LU/88/22/PL

Mewsbrook House Care Home 59-61 Street Littlehampton BN17 6AU

Installation of a second floor in the form of a mansard roof on the rear wing of the existing care home, replacement windows in the original wing of the property and the reconfiguration of a 9 No. bedrooms on the first floor to 7 No. larger bedrooms.

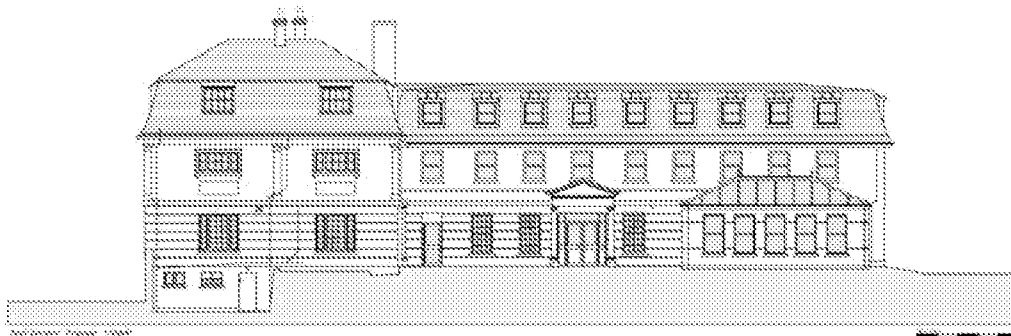
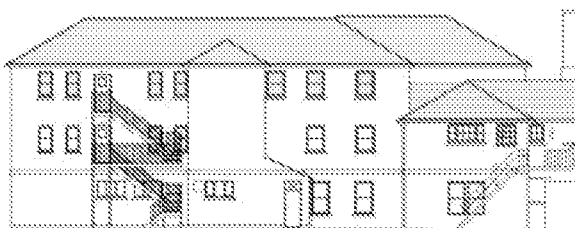
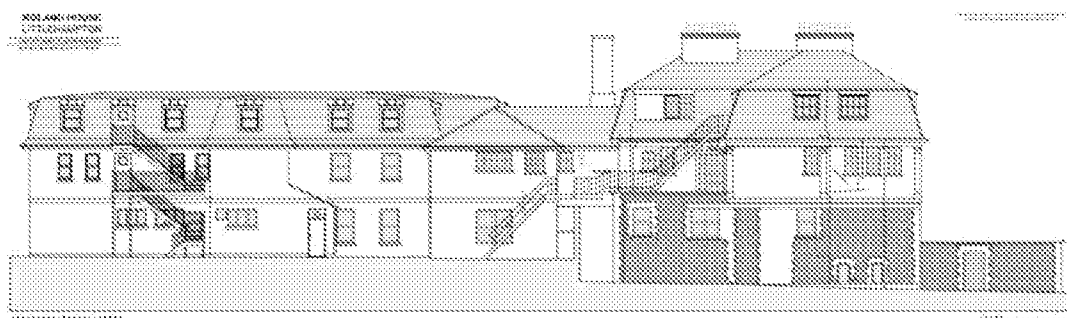
The proposed introduction of natural slated canted /mansard roofs improves their appearance and is also sympathetic with the form and massing of the original element of the building. Further, the additional floor will remain visually subservient to the core building, which is positive. It is therefore not considered to be harmful, subject to the use of appropriate materials. It is suggested that details of the natural slate be provided by way of condition, so as to ensure that it is appropriate for the listed building.

The statement identifies that the new Windows for the new build will be in a matching sash style to replicate all late C20 window details found on the rear care home extension wings. Whilst this is acceptable, I would want to be reassured that they are appropriate for their context. As a result, I would request further details regarding their appearance, dimensions, detailing, glazing etc. Such information can be provided by way of condition if the application is approved.

LEFT – South Elevation (Existing – UPVC Windows)

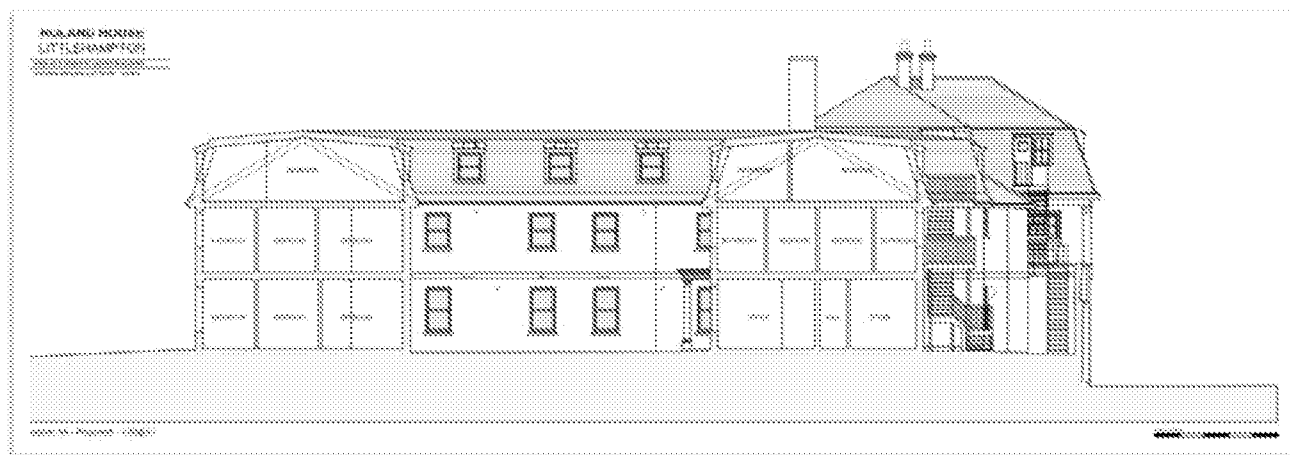
The DAS/heritage statement indicates that the existing inappropriate UPVC windows in the oldest part of the building (i.e. non C.20 element) will be replaced with sash windows to match the originals. This is a positive element of the proposals and represents conservation gain. This element can be supported as a positive approach, subject to further information regarding their detailed design and appearance (including glazing bar and glazing system details).
